From: Ellie White [REDACTED]
Sent: Wednesday, October 27, 2021 3:10 PM
To: Maria Tomalova <Maria.Tomalova@arun.gov.uk>
Subject: Stakers Farm

BARNS 1&2 PROPOSED SOUTH EAST ELEVATION
SHOWING SHUTTERS OPEN

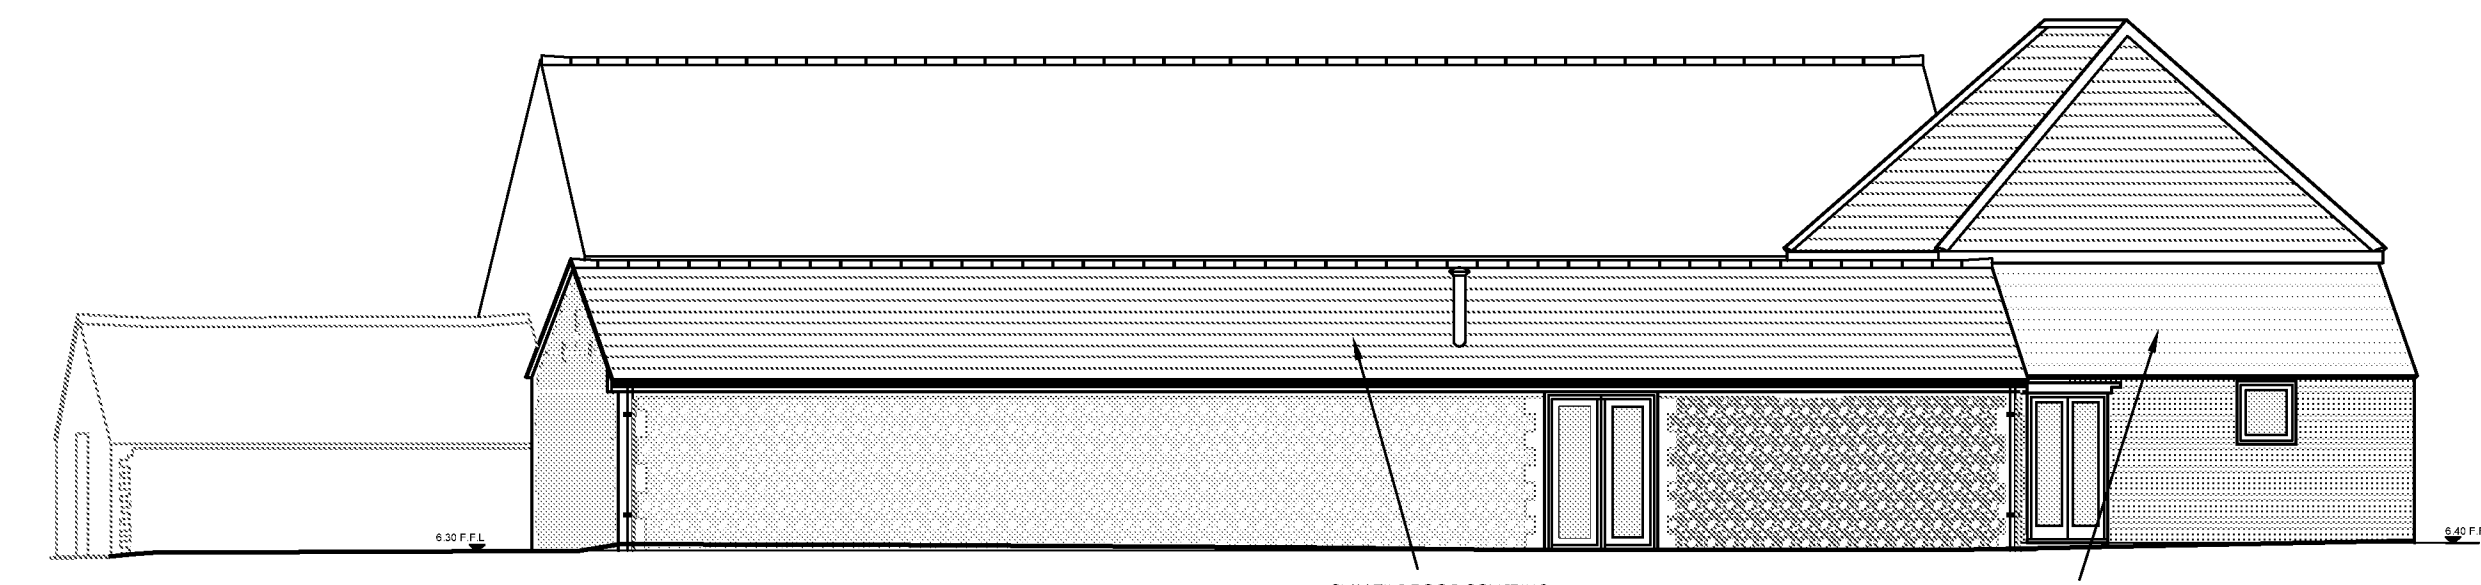
The windows to the south west elevation of Barn 1 follow the existing pattern of external doors to this area. The existing doors would simply be removed, and new full height windows or glazed doors fitted in their place. If required, full height external shutters could be fitted to provide a more rural appearance. However, the existing doors are now beyond repair and cannot be salvaged.
